Subject: 2026/90706 at location Mars Care And Treats Petcare Europe Ltd, Oakwell Way, Birstall, Batley, WF17 9LU

Please see ecological commentary below:

Portakabin		
Title Proposed Location & Block Plan		
MARS Petcare at Oakwell Way, Birstall, WF17 9LU		
Date: 25th November 2025		
Scale : 1:200 & 1:2500 @ A1		
Drawing Number TM420066885

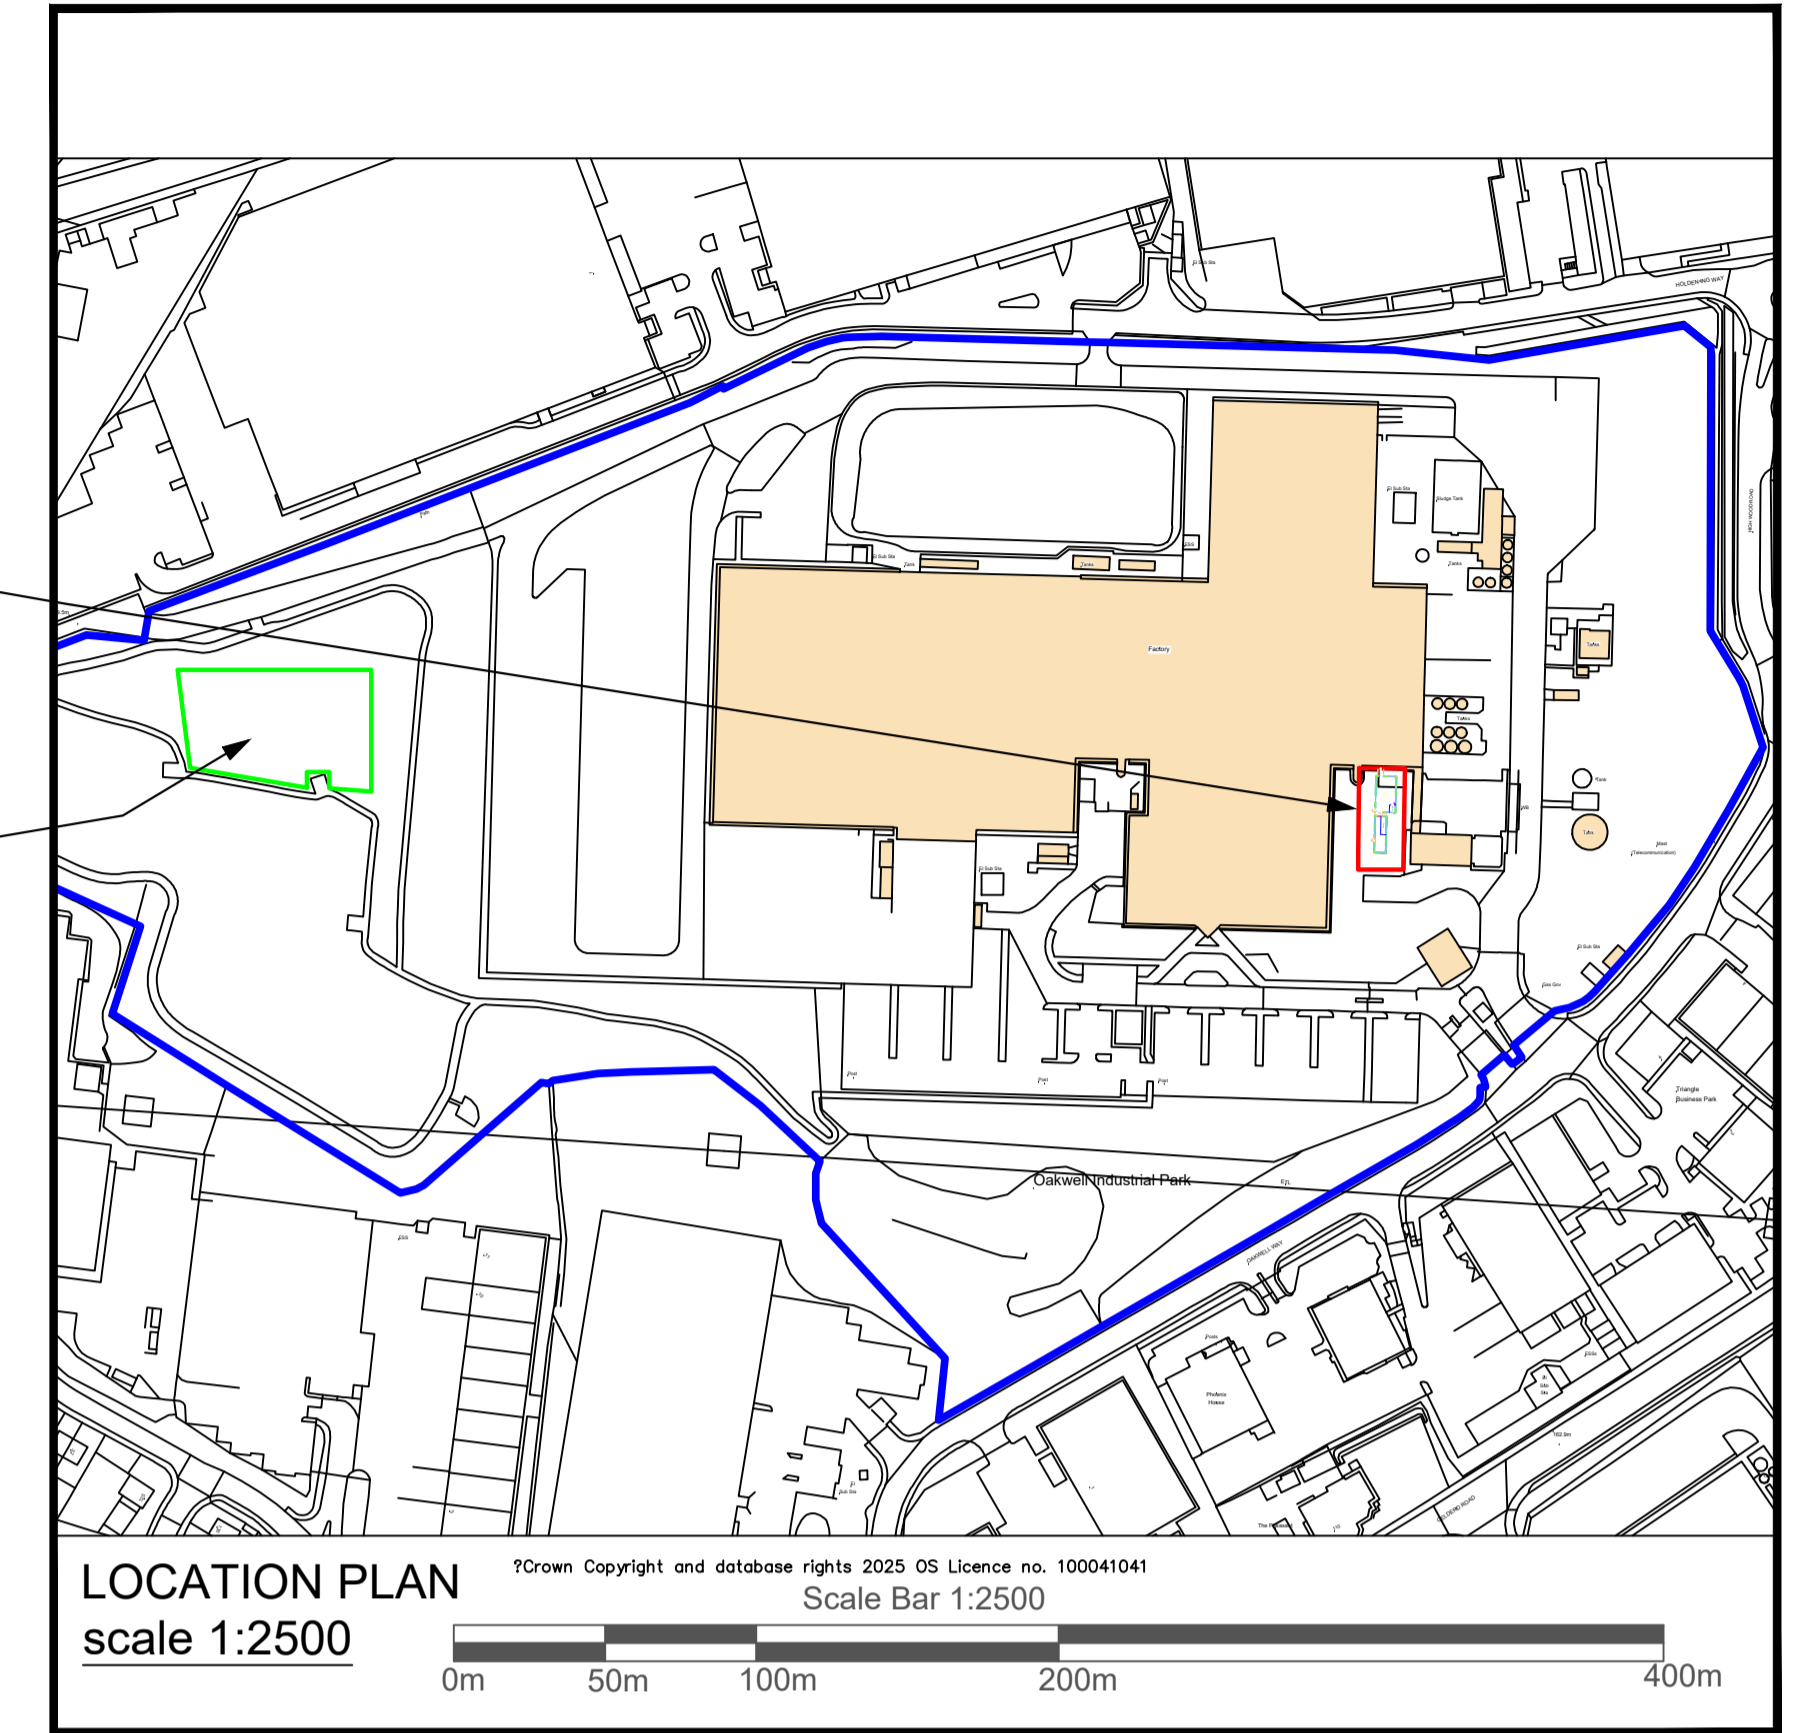
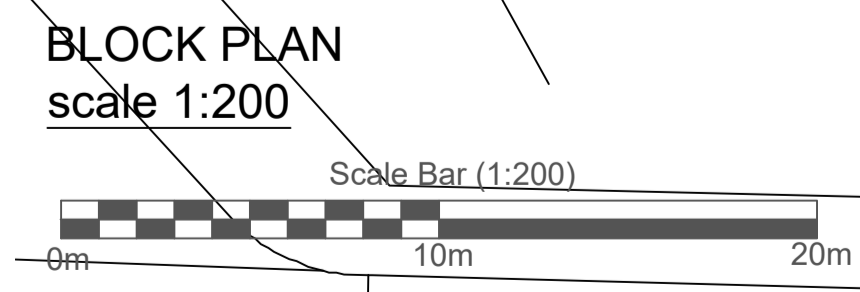
The site consists of grassland and a hedge. Due to the site being adjacent to a large industrial building and areas to the east and west offering greater opportunities – it is unlikely that species are using the site. Pre-works nesting bird check for the hedge will be conditioned.

No works to be buildings that may be used by breeding birds shall take place between 1st March and 31st August inclusive, unless a competent ecologist has undertaken a careful, detailed check of vegetation for active birds' nests immediately before the vegetation is cleared and provided written confirmation that no birds will be harmed and/or that there are appropriate measures in place to protect nesting bird interest on site. Any such written confirmation should be submitted to the local planning authority
